22 December 2020

PITT STREET NORTH SSD 8875 MOD 1 AND SSD 10375 STAGE 2 – RESPONSE TO CITY OF SYDNEY ADVICE ON RESPONSE TO SUBMISSIONS

Table 1 Response to CoS Request for Advice

Figure 31 | Car stacker and Loading dock layout (Source: RtS)

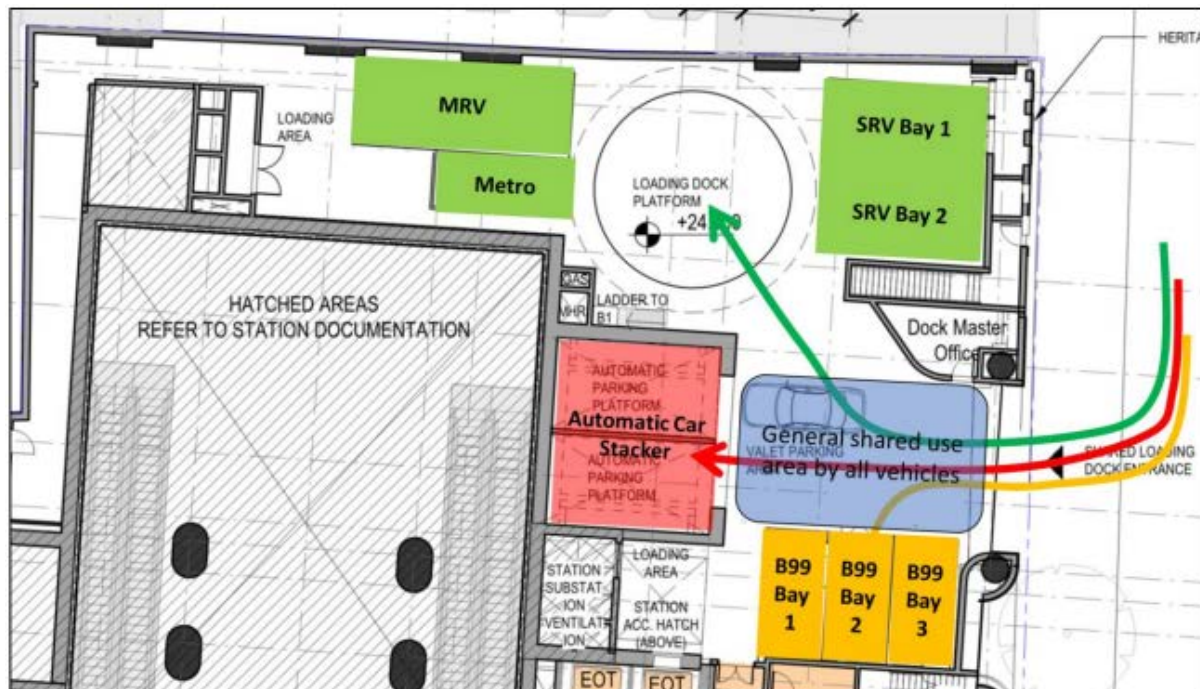
CoS RTS response	Applicant response
subsequently the proposed footpath level assessment cannot be carried out.	
2. Vehicle access and queuing arrangements	
<p>There is still some concern regarding the access arrangements. The current proposed access arrangements require vehicles waiting for the lifts (and entering and exiting the left) to use the shared space and impact on access to the loading areas. Access to the site for loading and servicing should be prioritised. A queuing assessment is also recommended to use the Australian Standard 98th percentile for access to mechanical parking installations.</p> <p>Further any safety measures that impact negatively on the public domain are not supported. Pedestrians using the footpath must have priority over vehicles entering and exiting the stie.</p>	<p>TfNSW has recommended a condition of consent to address any potential access/queuing issues in relation to the proposed development. The applicant supports the proposed condition.</p> <p>DPIE’s support of this condition is requested as this will, in our view, address this aspect of the CoS RTS response.</p> <p>The condition recommended by TfNSW is as follows:</p> <p><i>Prior to the issue of the Occupation Certificate, the applicant shall prepare a detailed Car Parking, Loading and Servicing Management Plan in consultation with TfNSW by updating the Service Delivery Plan. This plan shall ensure that any potential traffic and safety impacts associated with the car park and loading dock operation are mitigated. The applicant shall submit a copy of the final plan for TfNSW endorsement. The Plan needs to specify, but not be limited to, the following:</i></p> <ul style="list-style-type: none"> • <i>Details of the development’s loading and servicing profile, including the forecast loading and servicing traffic volumes by vehicle size, frequency, time of day and duration of stay;</i> • <i>Details of measures to manage any potential traffic and safety impacts of the car parking and loading dock operation in particular potential queuing on Pitt Street and safety incidents between car users accessing the automatic car stacker and service vehicles</i>

CoS RTS response	Applicant response
	<p><i>as well as between cars and service vehicles; and</i></p> <ul style="list-style-type: none"> <i>Details of how vehicles larger than a 6.4m SRV delivering to the site shall be managed. The Car Parking, Loading and Servicing Management shall be implemented by the applicant following the issue of the Occupation Certificate.</i>
<p>3. Loading and servicing</p>	
<p>Loading and servicing rates should be provided as per the Sydney DCP 2012. The development is a new development and loading and servicing needs should be accommodated onsite. The access arrangements, including proposed management arrangements, and parking provision should prioritise loading and servicing.</p>	<p>Noted. The proposed development is in accordance with CoS requirements.</p>
<p>4. Car parking</p>	
<p>The City notes and accepts the applicant's response regarding car parking within the site.</p>	<p>The City's agreement to the applicant's response is noted.</p>
